Please ask for: Nicola Moore
Email: nicola.moore@arun.gov.uk
Telephone: Ext 37944
Our Ref: R/151/20/CLP
Your Ref:
Date: 27th August 2020

Lawful Development Certificate for a Proposed Use or Development

Development: Lawful development certificate for a proposed single storey rear extension.
Location: Brambles Hurst Road East Preston BN16 3AP

Existing Elevations

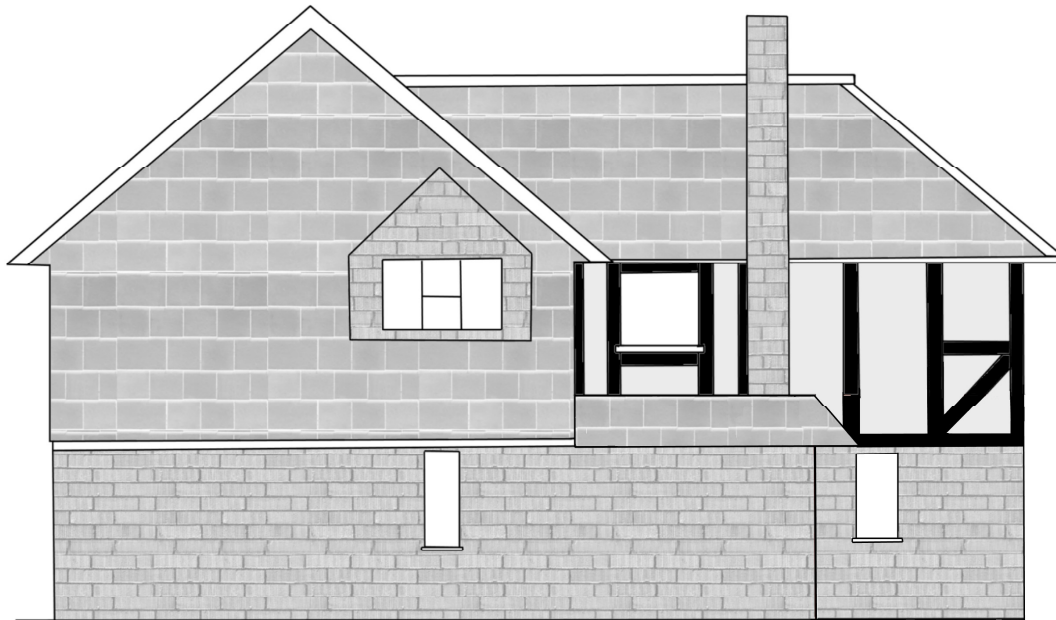
Please submit 1 electronic or 3 paper copies of clearly labelled existing elevations, including either a scale bar at 1:50 or 1:100 or measurements.

Elevations showing proposed extension outlined in red.

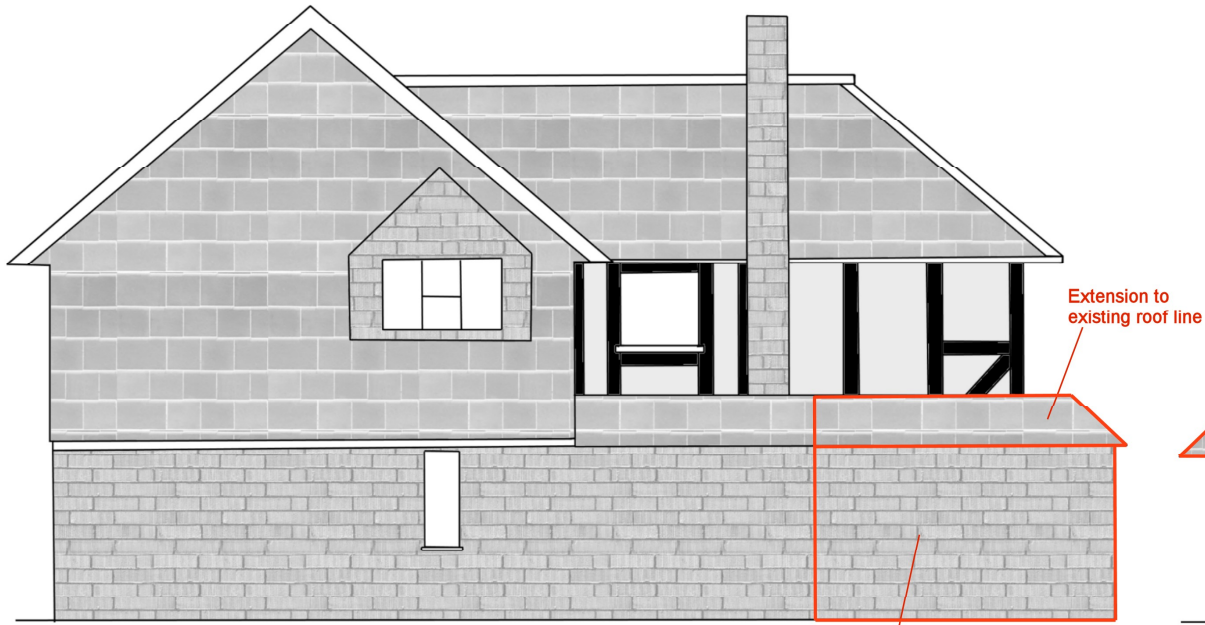
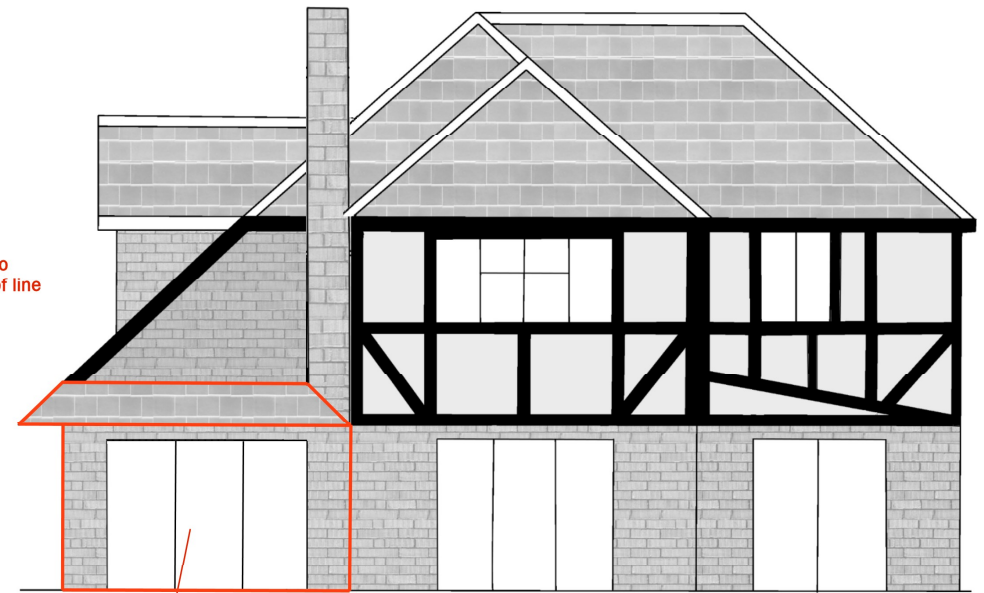
Please clearly label the proposed elevations and include either a scale bar at 1:50 or 1:100 or measurements of doors and windows and the proposed extension and re submit. Further details can be found in the Validation Requirements List.

Front of property
Scale 1 : 100 at A4

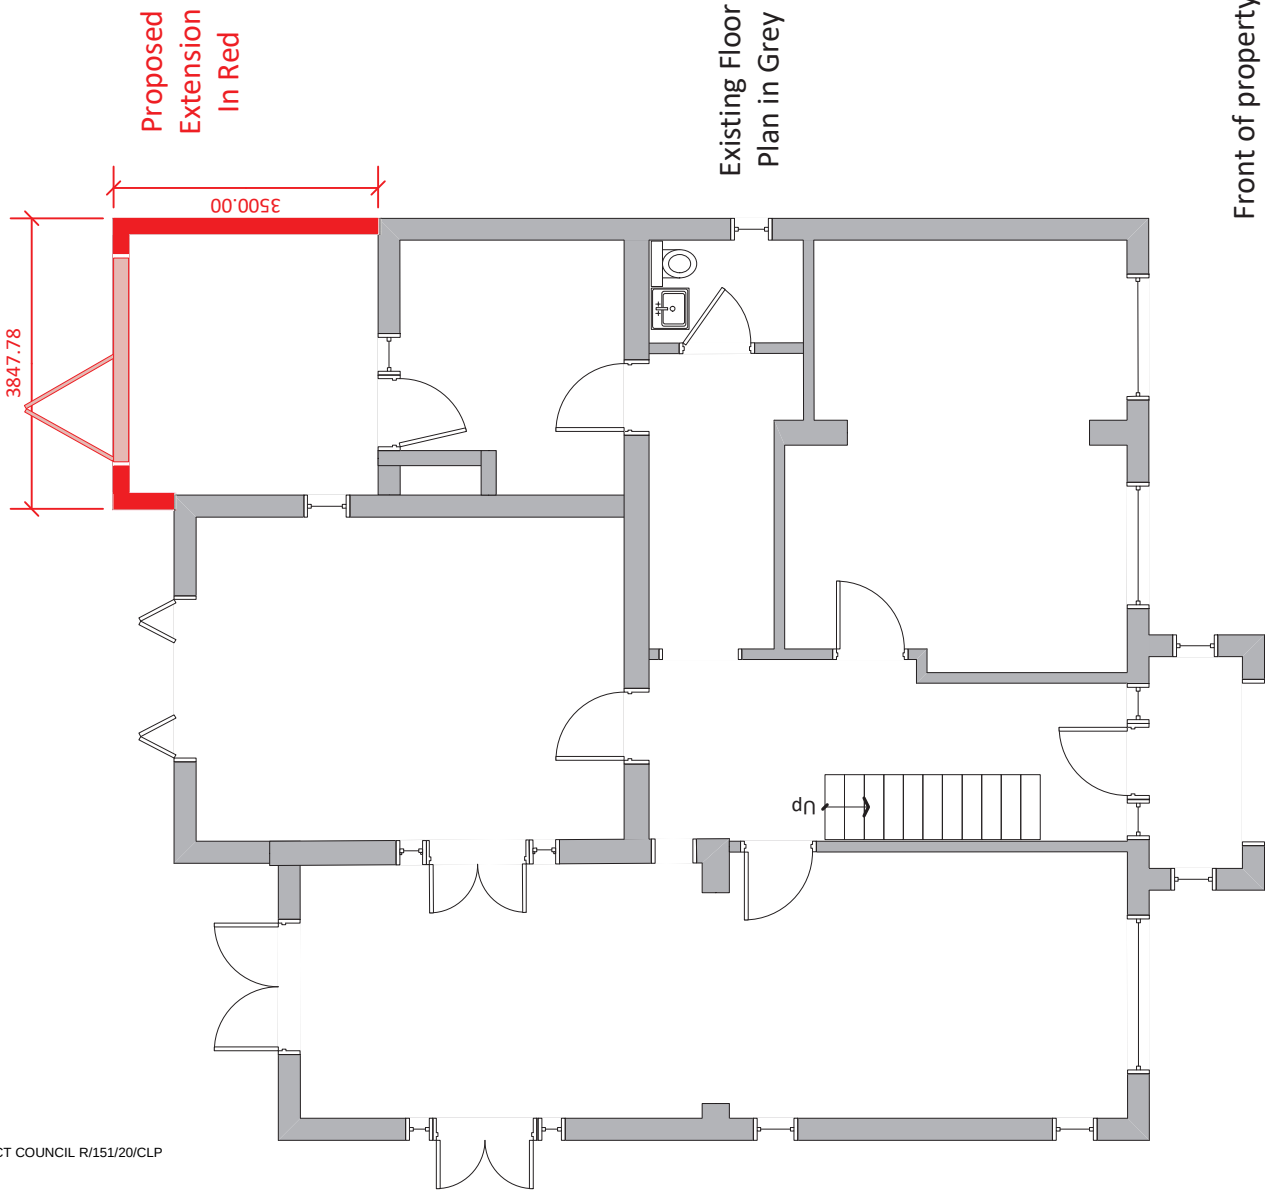
The plans should include either a scale bar or measurements of windows/doors and the proposed development, and be clearly labelled to show the existing and proposed. Please amend accordingly and resubmit. Further details can be found in the Validation Requirements List.
